2021/0782

Bence Farm House, Barnsley Road, Darton, Barnsley, S75 5NT

Proposed Extension:

D1000-02 - A

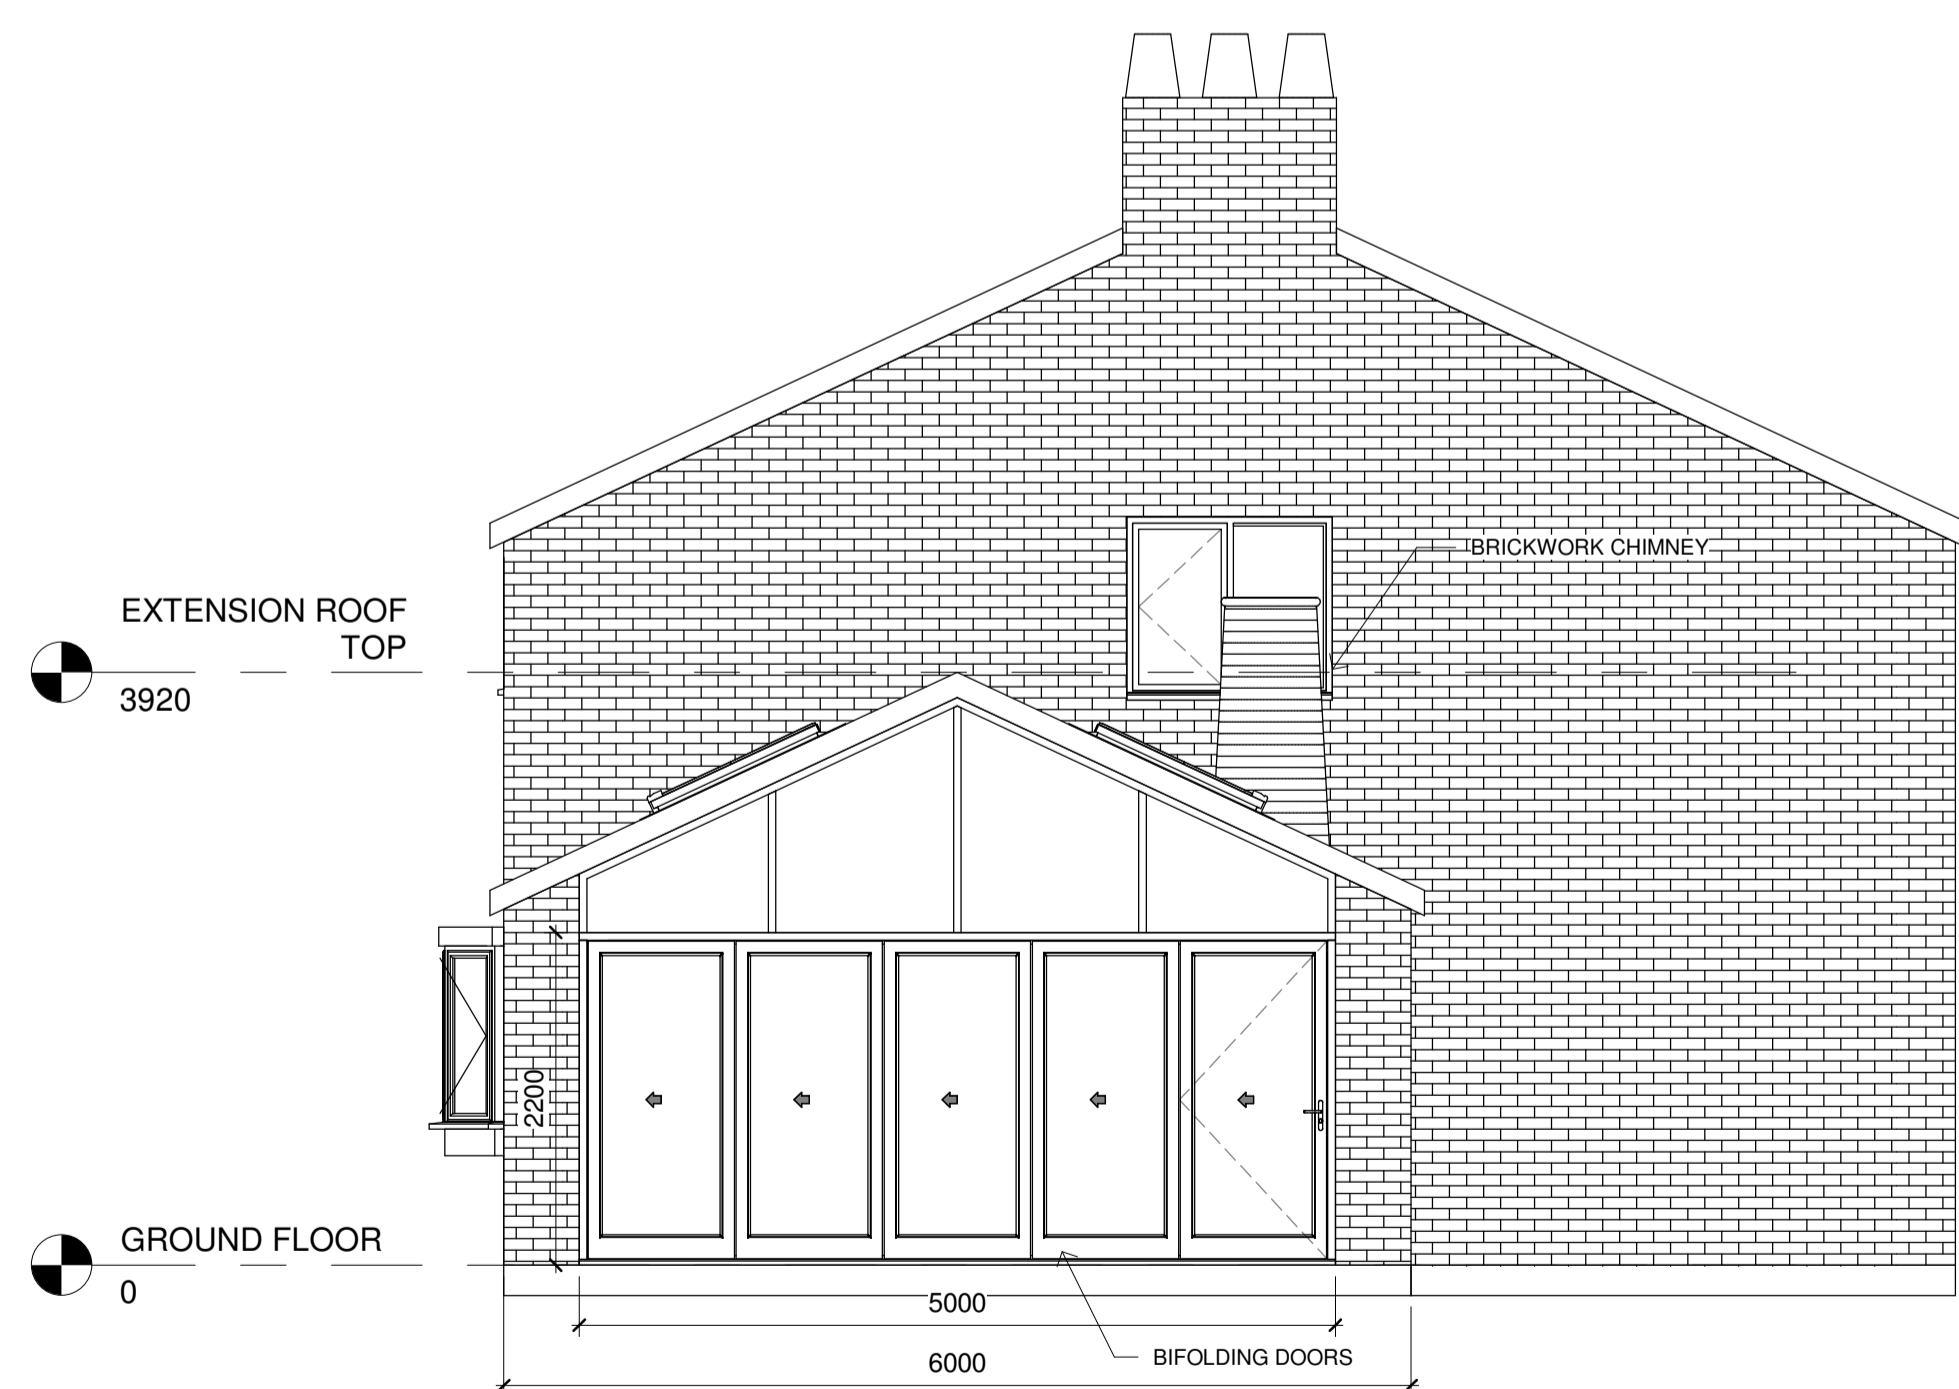
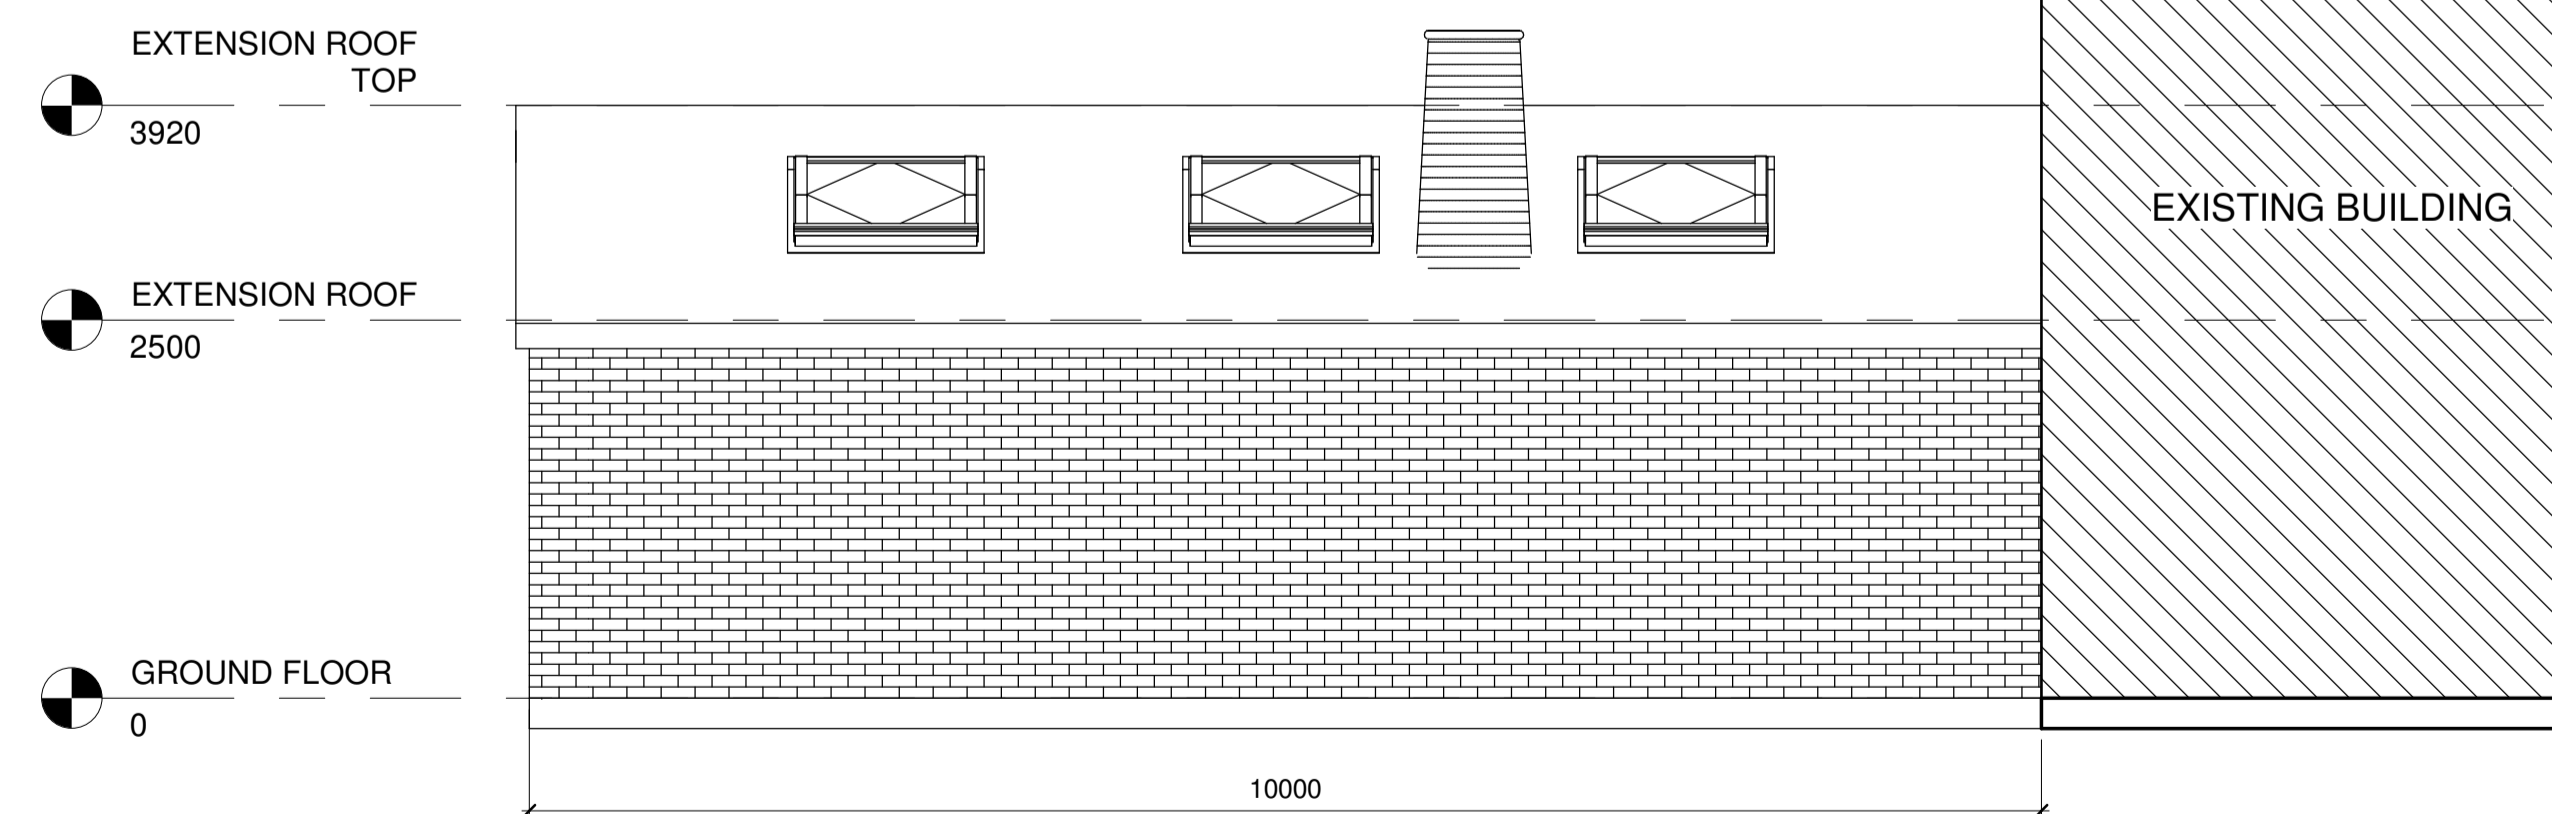
The proposal has been amended during the course of the application and the application now proposes a single storey side extension. The design of the extension has been amended from a metal

clad structure to matching stone with a pitched roof with matching tiles. The size of the extension has been reduced by 0.5m in projection so that it now measures 10m by 6m in width. The proposed extension has 3 rooflights on each roof slope and a glazed gable with glazed doors. The access which was originally proposed to Barnsley Road has also been removed from the proposal.

4. roof design corresponds to existing	Yes
5. windows / doors of a similar design / proportion	Yes no windows to side (apart from high level rooflights which will not overlook) but glazed elevation which is acceptable in terms of design.

6. habitable room windows on the side elevation	No
7. materials to match	Yes – agent confirmed stone to the front and brick to side with roof tiles to match.
